Examiners questions.

10.8.28 Applicant Document: EN01041-000182-6.1 ES Vol 1 Chapter 10 Noise and Vibration PO1.pdf

Figure 10-1 Noise Monitoring Positions and Noise Sensitive Receptors (Rev P01)

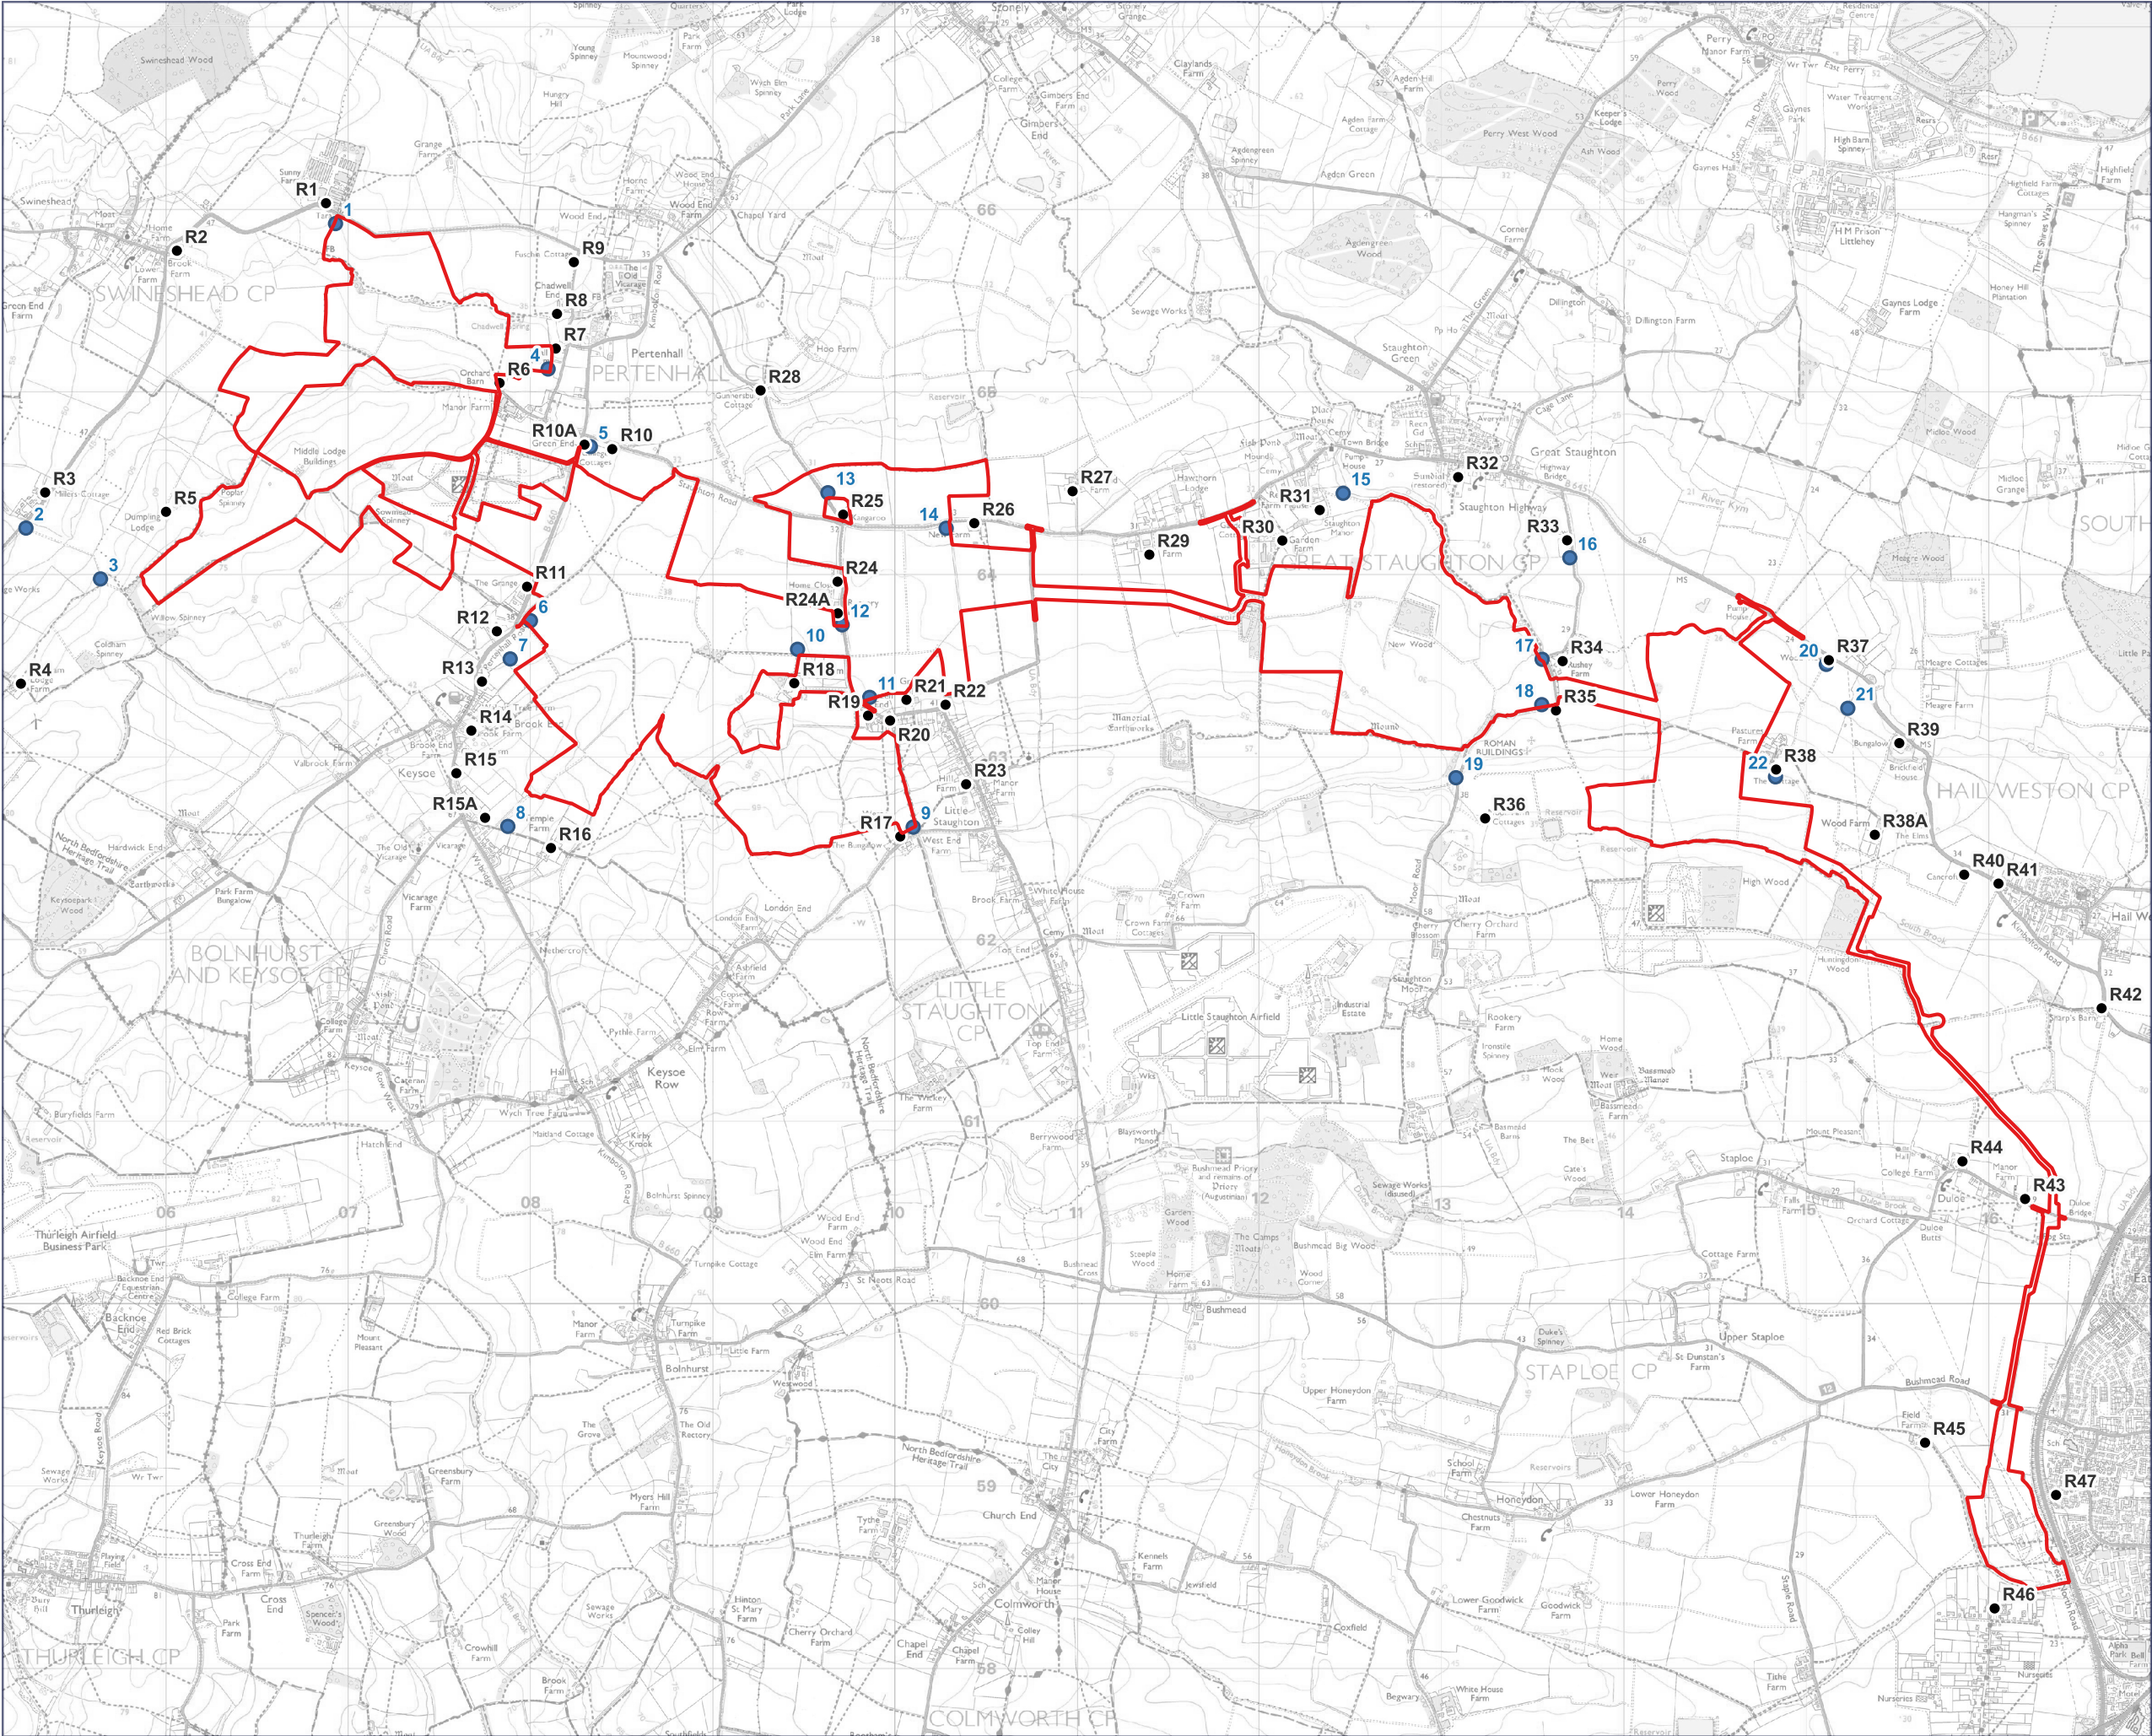
NMP5: College Cottage 508326, 264701 Baseline measured at rear of property boundary in field to east. Noise climate generally formed by local road traffic noise & birdsong. Farm activities may occur at certain times of the year. Site A slight or negligible throughout.

*I would suggest this study is extended to the boundary [REDACTED] [REDACTED] on the opposite side of the B660 in Green End and closer to the hardcore, single-track road which is to be used for access to site A. The track runs the length of [REDACTED] boundary and the noise of HGVs and other construction traffic traversing the unmade, hardcore track for most of the day between 7 am to 6pm for 30 months should be anticipated.*

To include my property in the list on page 66 due to the proximity to Site A and to the access road. “Routing of plant and vehicles will be optimised to minimise noise at sensitive locations’ – *how will that work when temporary roads or unmade roads have already been designated?*
